State of Washington
DEPARTMENT OF FISH AND WILDLIFE

March 8, 2023

SUBJECT: WDFW COMMENTS ON SE-23-00009 NELSON VIEW SUBDIVISION

Figure 1. LiDAR imagery of the channel scar through the project area, west of Big Creek.

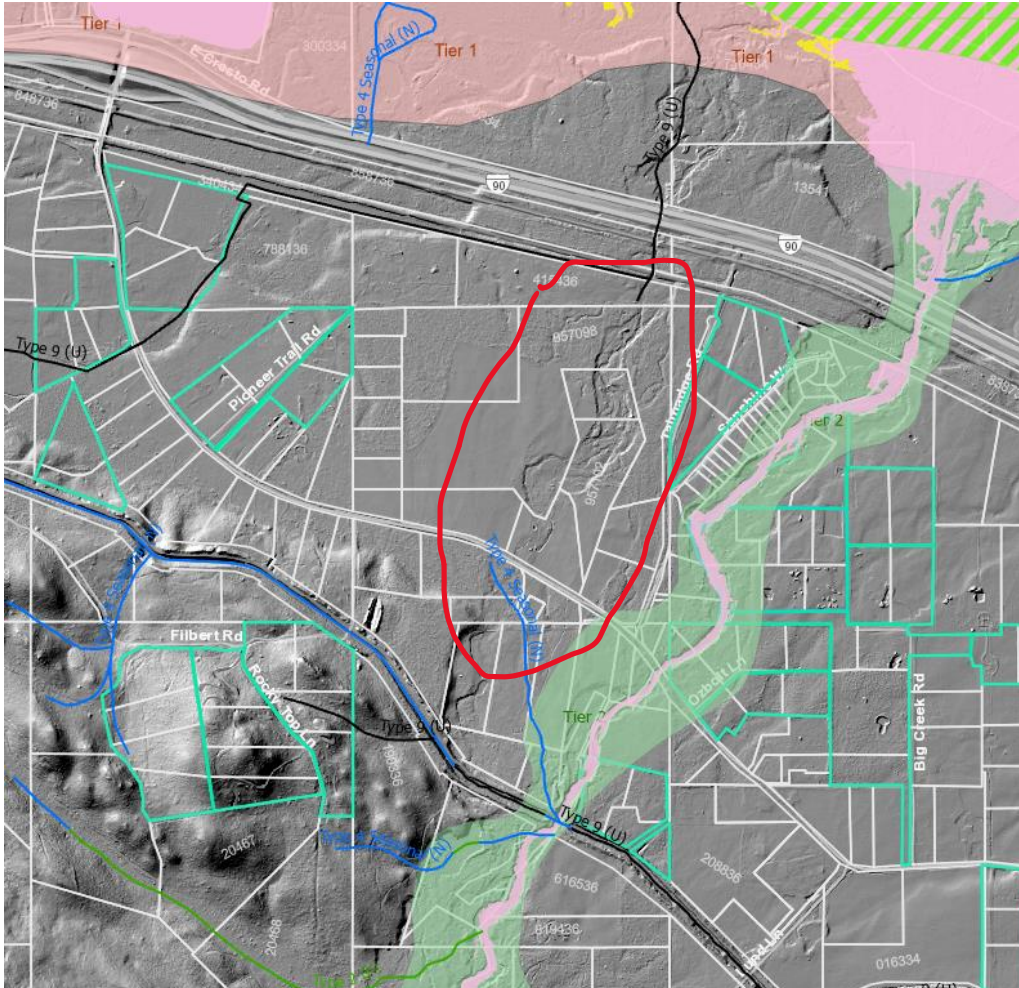
While the project area is not immediately adjacent to Big Creek, the LiDar clearly shows a relic channel through several of the proposed lots (Figure 1), specifically lots 6, 9, and 10. If you follow the scar upgradient, it may be that this scar represents the historic irrigation channel, that was likely an old Big Creek channel in geologic time. Where this channel appears to start is just south of the KRD's canal and within the mapped Channel Migration Zone for Big Creek. This could result in channel avulsions or flood flow conveyance through the relic channel that the proponents/owners should be made aware of, despite not being mapped as a special flood hazard area by FEMA.

- A critical areas report should be submitted for the project because there appear to be potential wetlands present and there are untyped streams present at the northern portion of the property. The critical areas report should also cover the geological hazards associated with the channel migration zone along Big Creek that may result in flow entering the channel scar through the project area. This project area is mapped as a Tier 1 for Critical Aquifer Recharge Area as well. The Critical Areas report should address all 5 critical areas that may be present or near the project area. The untyped stream mapped at the northern extent of the property appears to have conveyance infrastructure through the railroad grade and Interstate 90, connecting it to the Yakima River. This channel may provide fish habitat and warrants further investigation.
